COMMUNITY DEVELOPMENT DEPARTMENT
80 Columbia Avenue ♦ Marysville, WA 98270
(360) 363-8100 ♦ (360) 651-5099 FAX

Re: Maryville Corporate Center – *Technical Review 2*
PA 22004

PRELIMINARY BSP COMMENTS

Amend all applicable sheets per the redlines included on this sheet

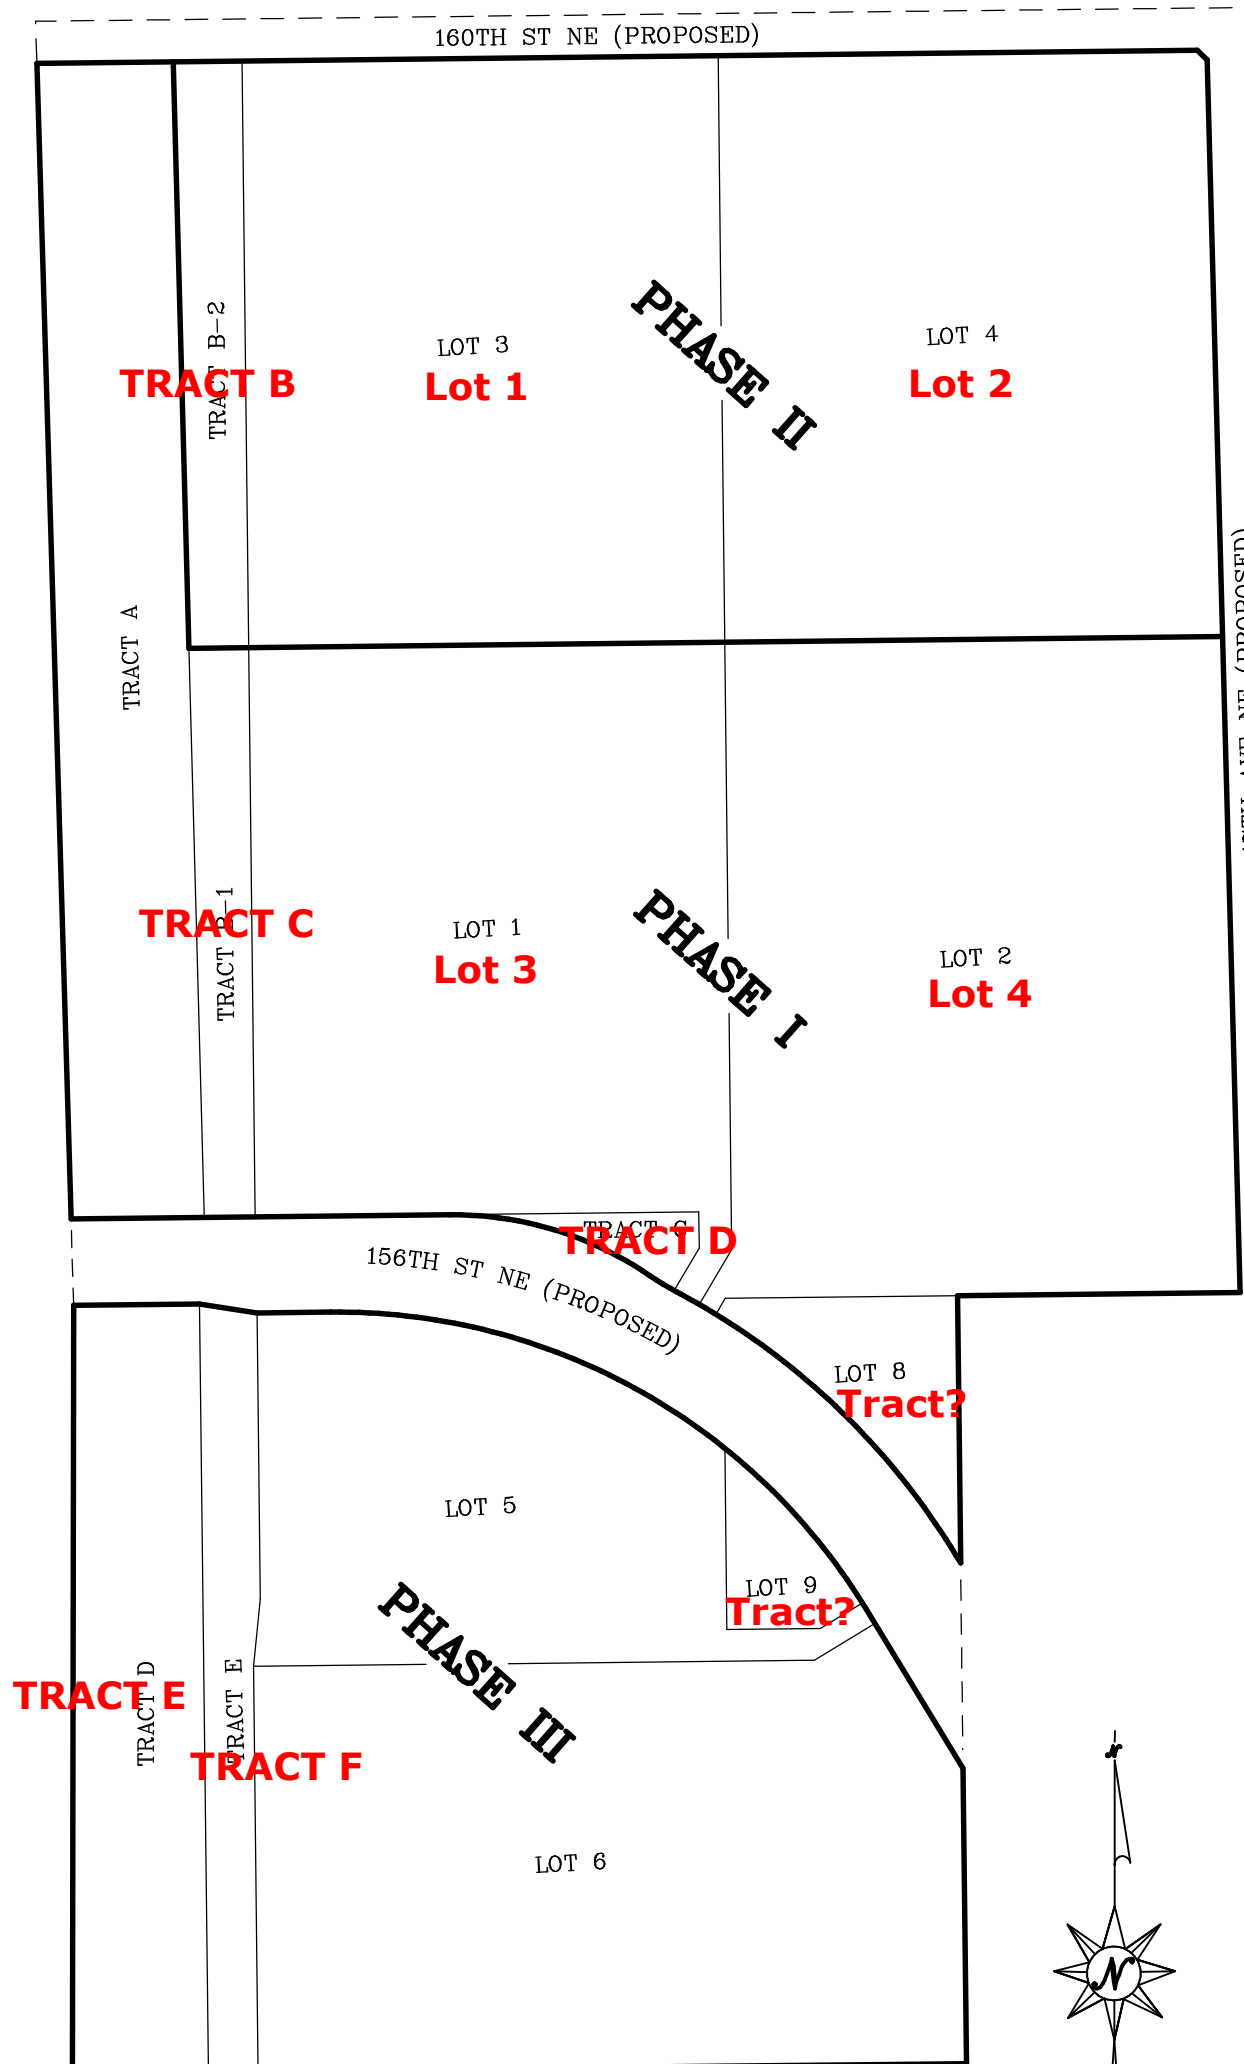
- e. As noted in the TR1 comments, pedestrian connections are required to be provided in accordance with [MMC 22C.130.050\(5\)\(c\)](#) (see attached redlines). Additional provisions are outlined in Section 9.7 of the Smokey Point Master Plan Design Guidelines.

TR2 Comment: Pedestrian connections as outlined in the attached redlines have not all been depicted on the preliminary BSP. Please amend all applicable sheets to provide pedestrian connections that traverse the drive aisles, as shown in the attached redlines.
